Our ref: DOC19/899609

Senders ref: SSI 9687

Subject: Snowy 2.0 Main Works Environmental Impact Assessment – EES Submission

ATTACHMENT A: Assessment Summary for Snowy 2.0 Main Works (SSI 9687)

Conceptual Site Model – Plateau

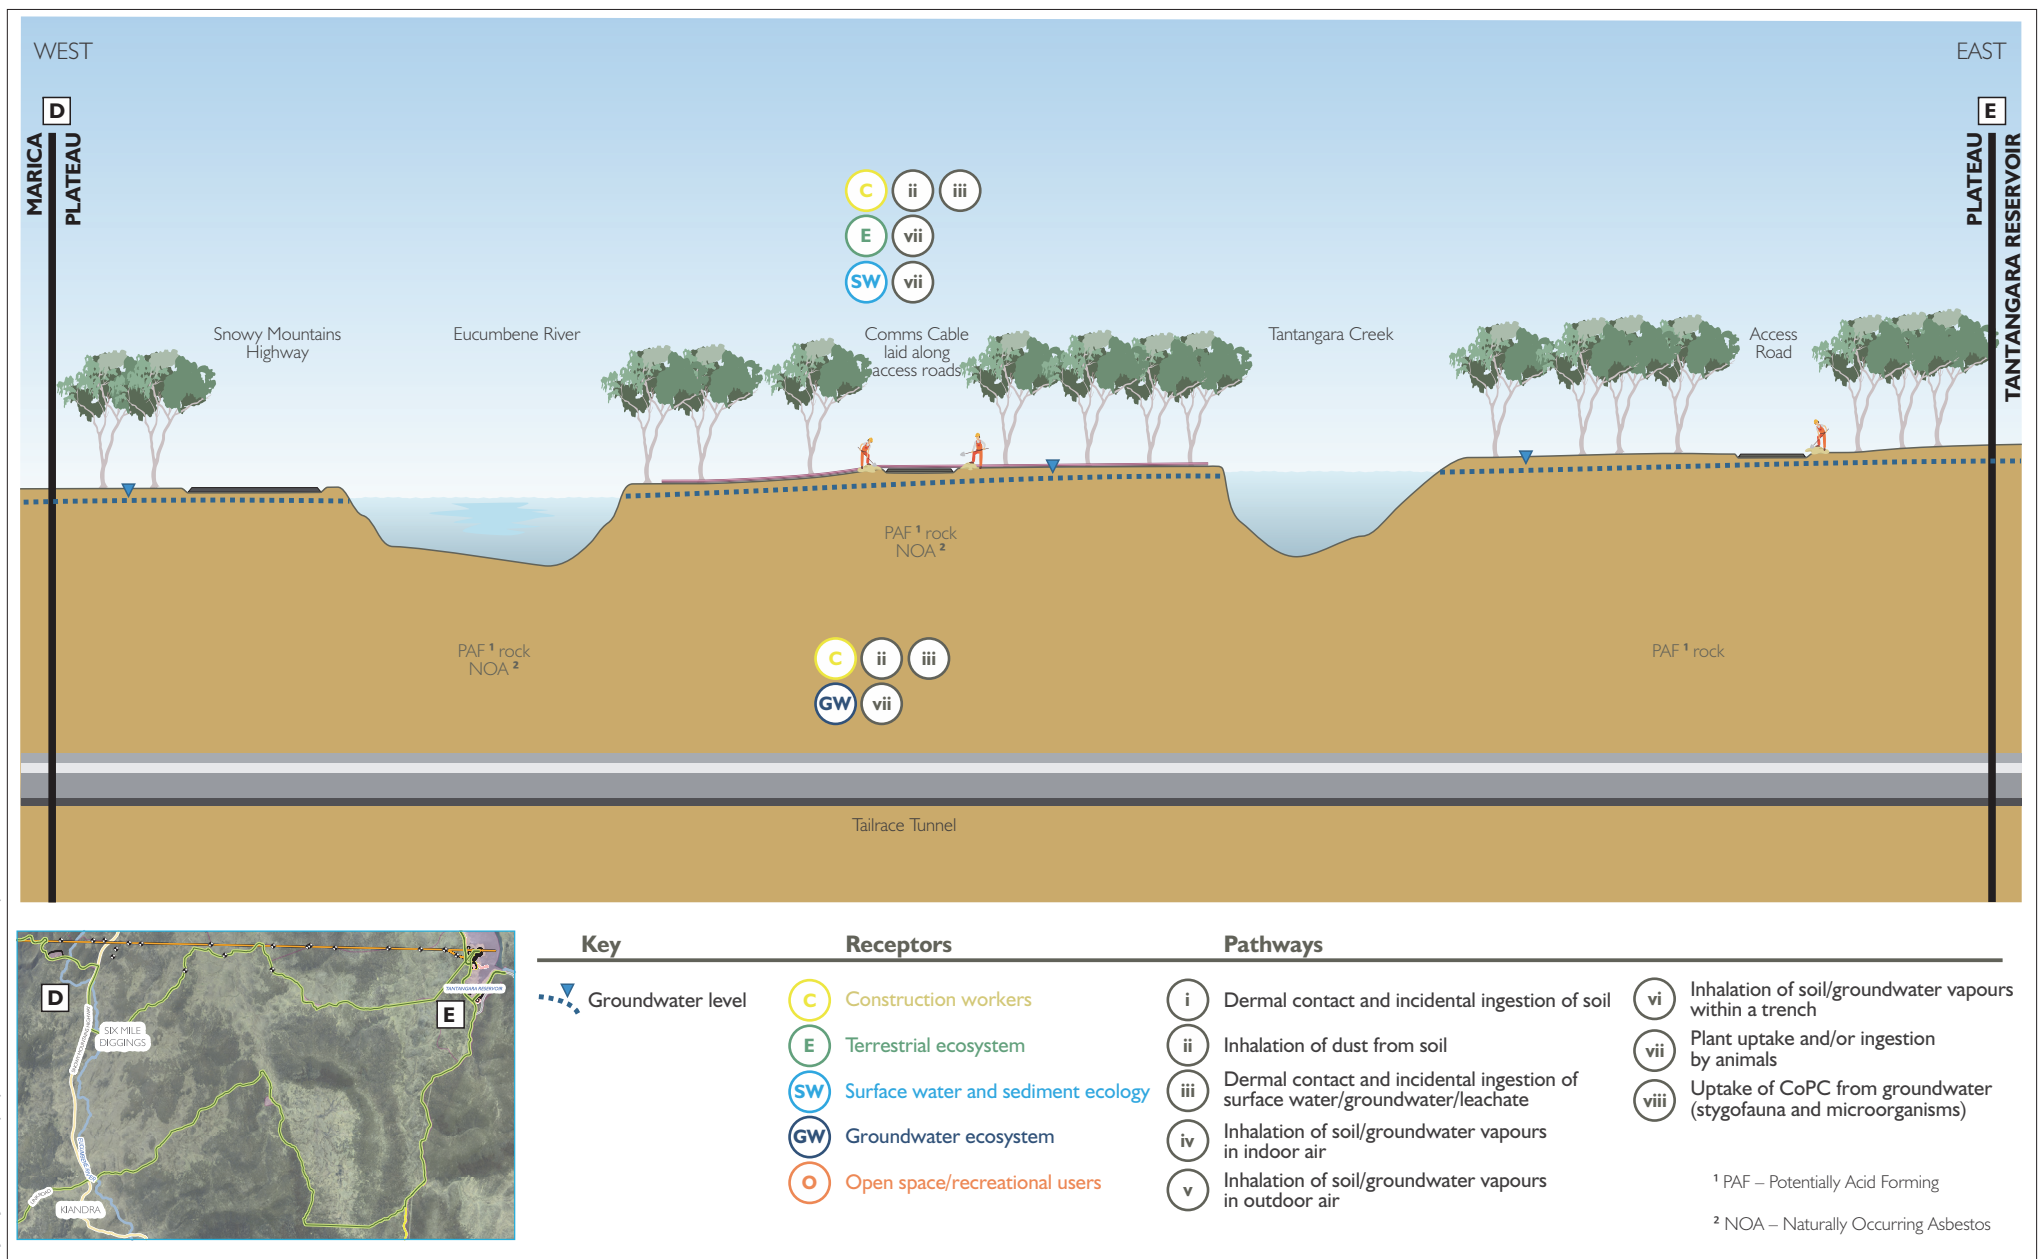
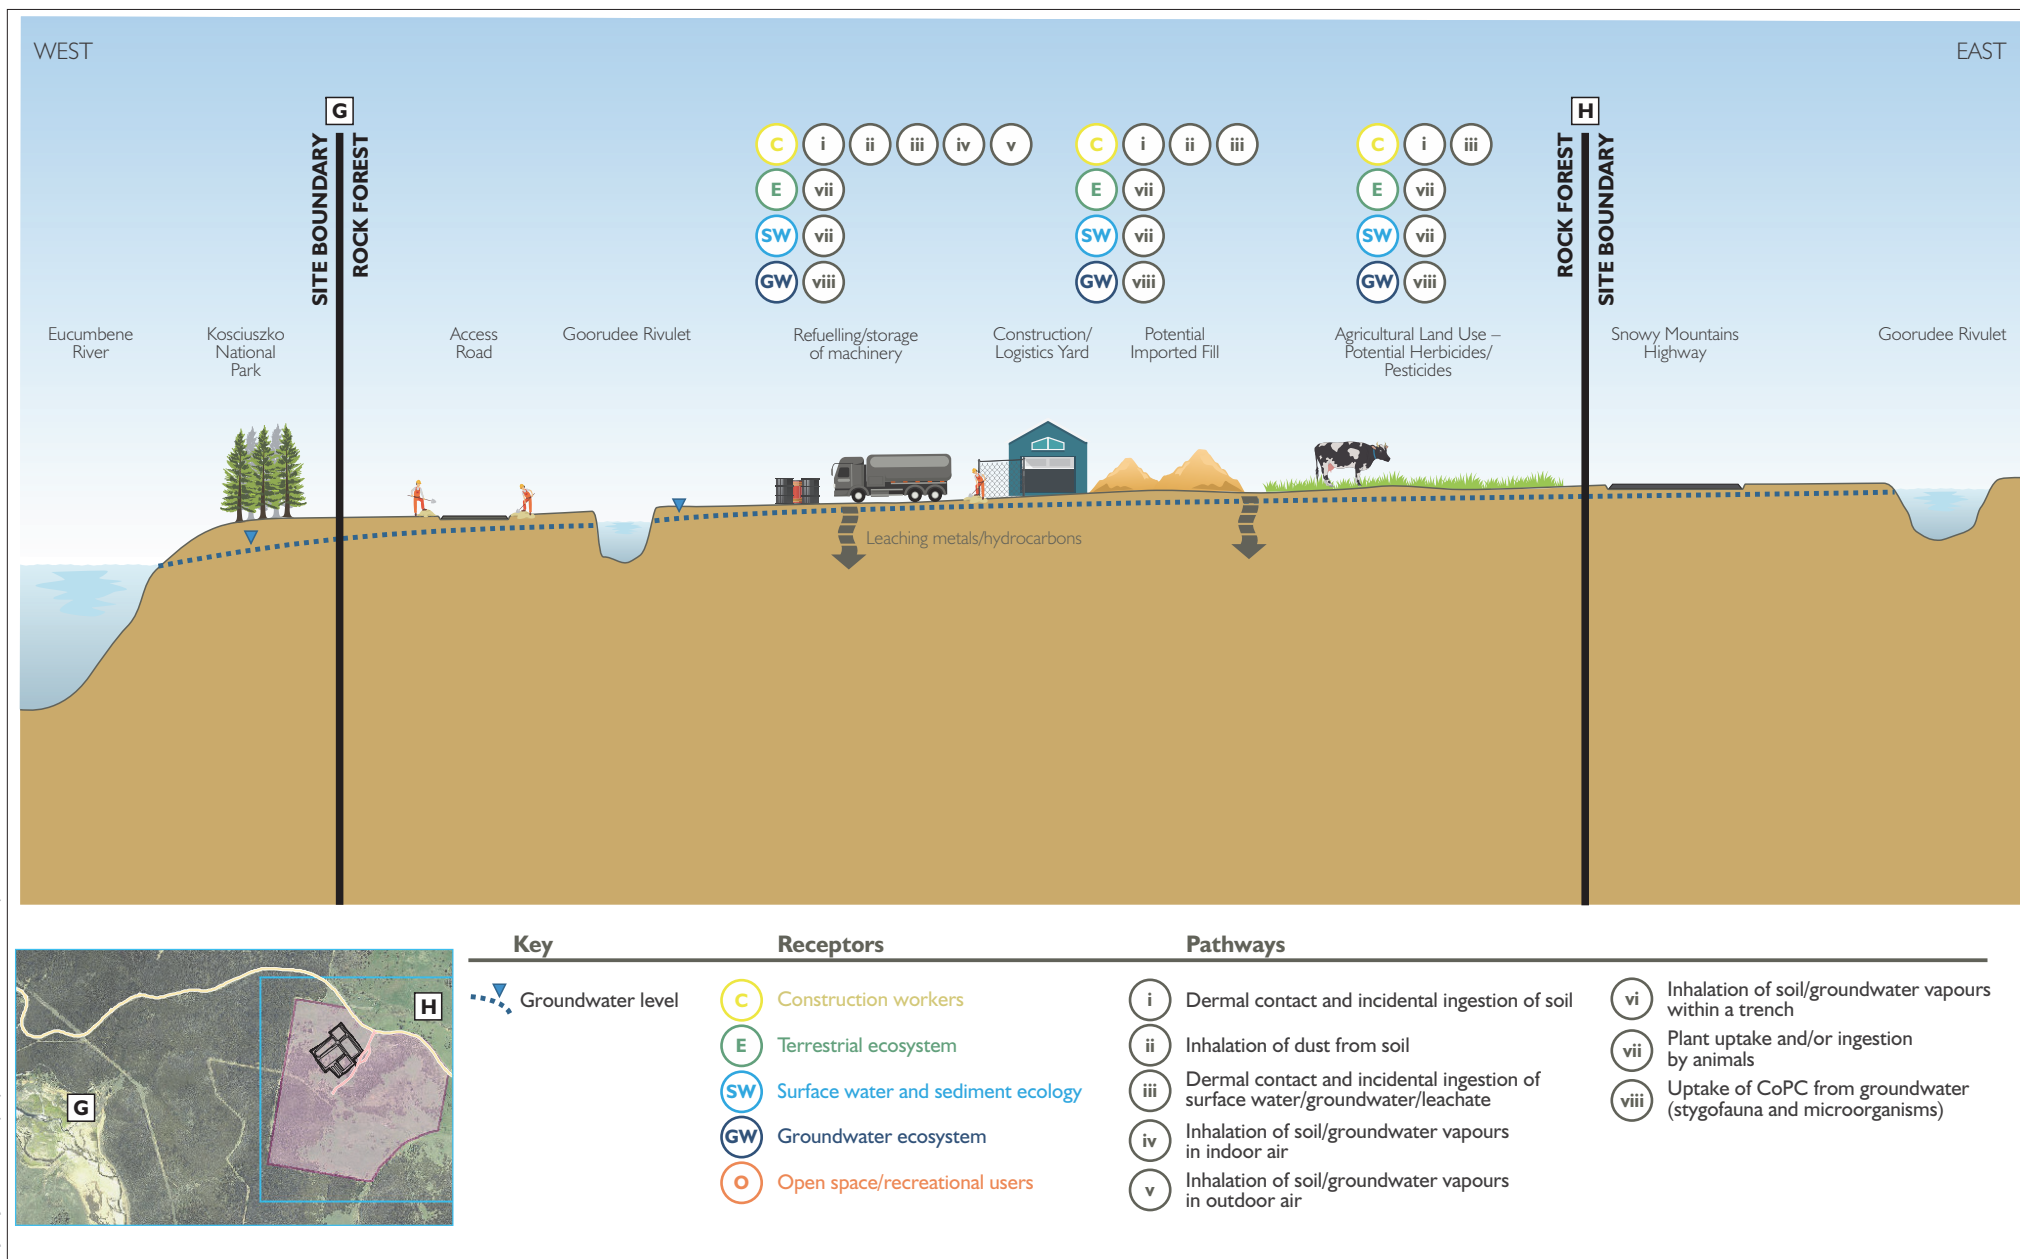
9	Hazards	<p>Issues:</p> <p>1) the EIS identifies a significant quantity of excavated spoil will be placed on land in KNP. The contamination assessment conceptual site model for Lobs Hole Figure 6.22 also indicates possible pathways impacting on recreational users.</p> <p>2) MW EIS p.6-82 identifies impacts to the Traces Knob quarry site as part of the project.</p> <p>3) MW EIS Table 6.36 secondary access options.</p> <p>4) MW EIS Table 6.37 identifies hazard mitigation measures which require clarification.</p> <p>5) Appendix T Bushfire assessment requires clarification.</p> <p>Recommended action/conditions of approval:</p> <p>1) the CoA obligate SHL to ongoing monitoring/ maintenance and contamination removal (during both construction and operational phases) if required of any spoil emplacement.</p> <p>2) the CoA place obligations on SHL for ensuring the stability and safety at Traces Knob quarry to address “<i>potential safety issues concerning unstable rock walls at the quarry</i>” raised in Appendix O.2 Section 4.2.</p> <p>3)</p> <p>a) clarification is provided as to the secondary access for Marica as being “<i>North on Lobs Hole Ravine Road to Snowy Mountains</i>”</p>

Figure 3-1: PCTs within the construction envelope (EIS, EMM)

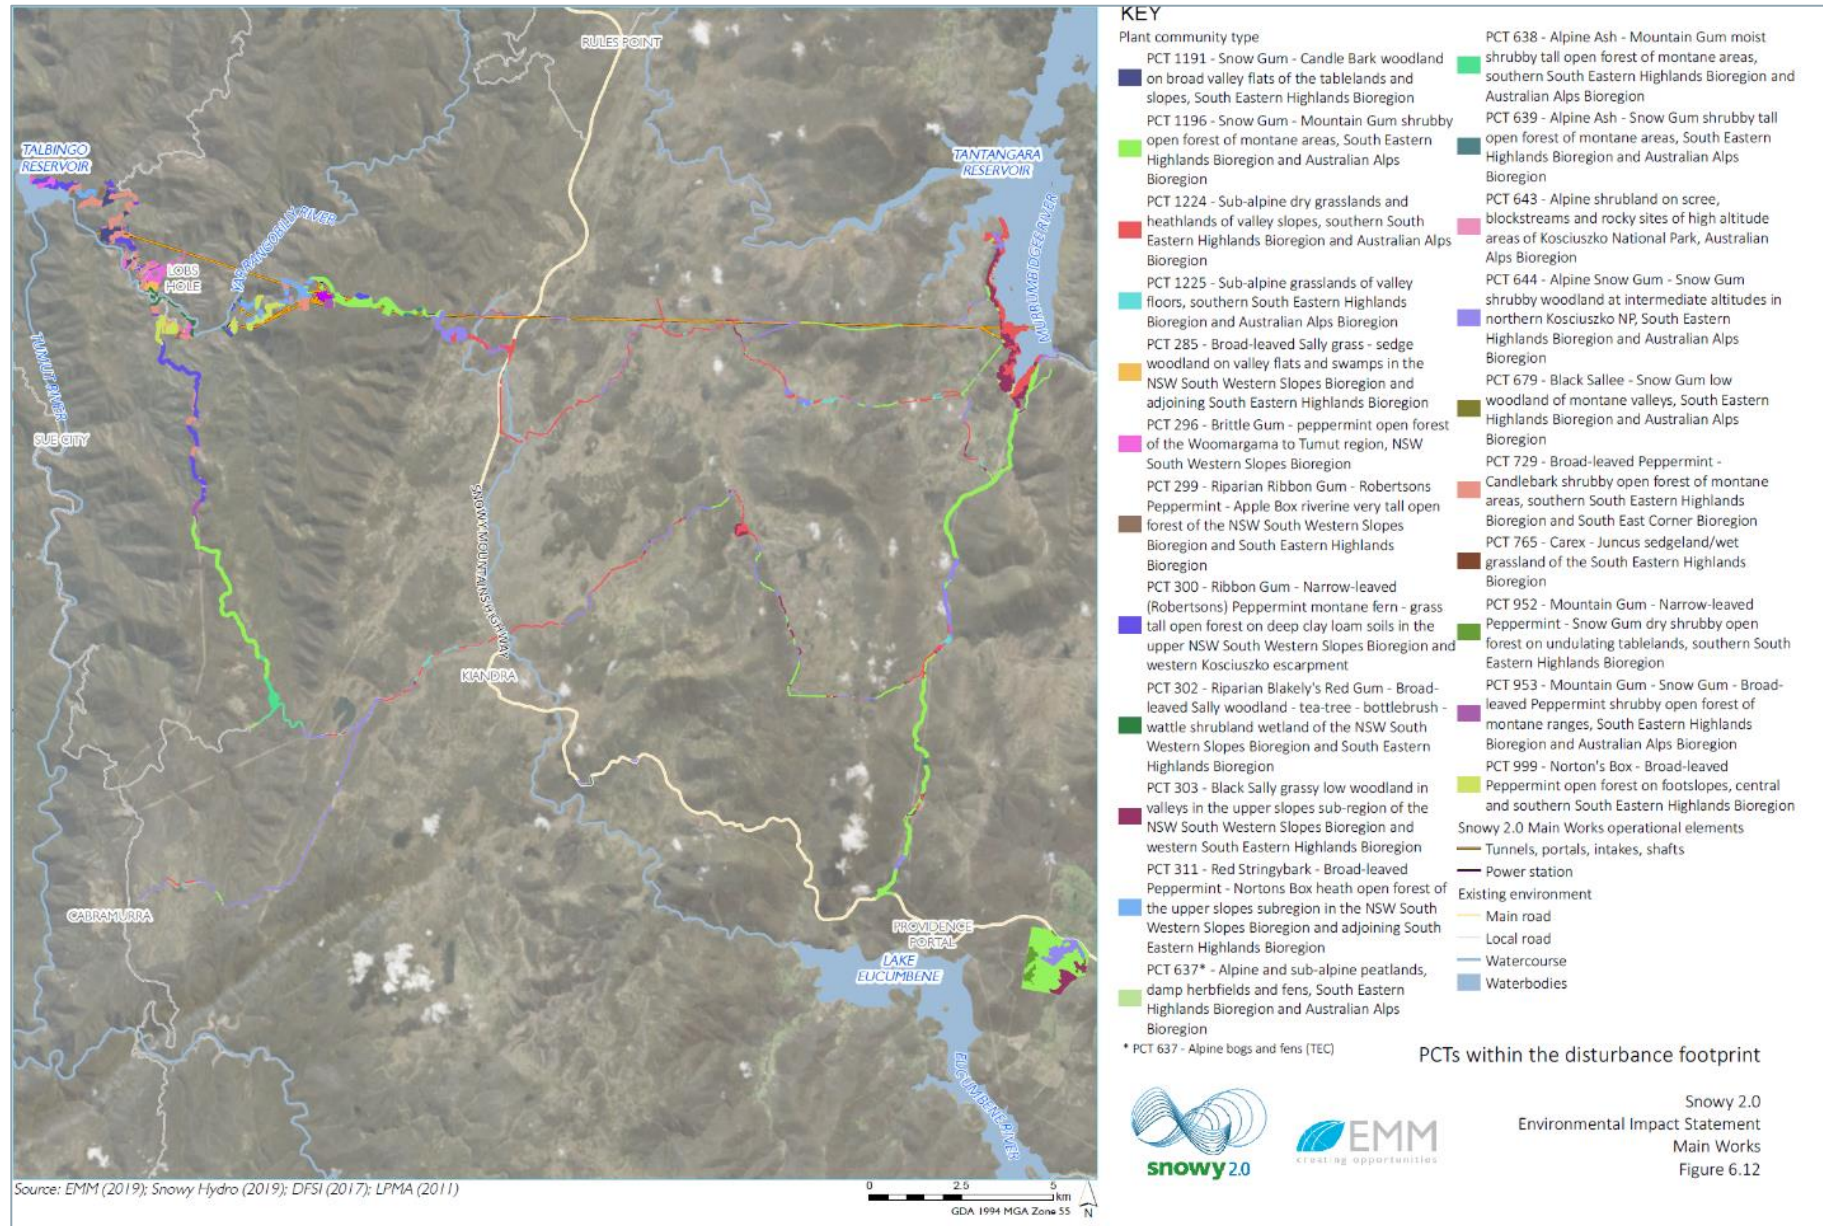
- placement of spoil on land within Kosciuszko National Park is not supported. Appropriate compensation to NPWS would be necessary if this is approved
- the EIS does not clearly delineate and quantify all the areas that will be impacted. Instead it describes broad impact corridors and gives the impression that a far greater area will be impacted than will actually occur. Detailed designs therefore need to be provided which show how impacts on biodiversity have been avoided and what the residual impacts will be
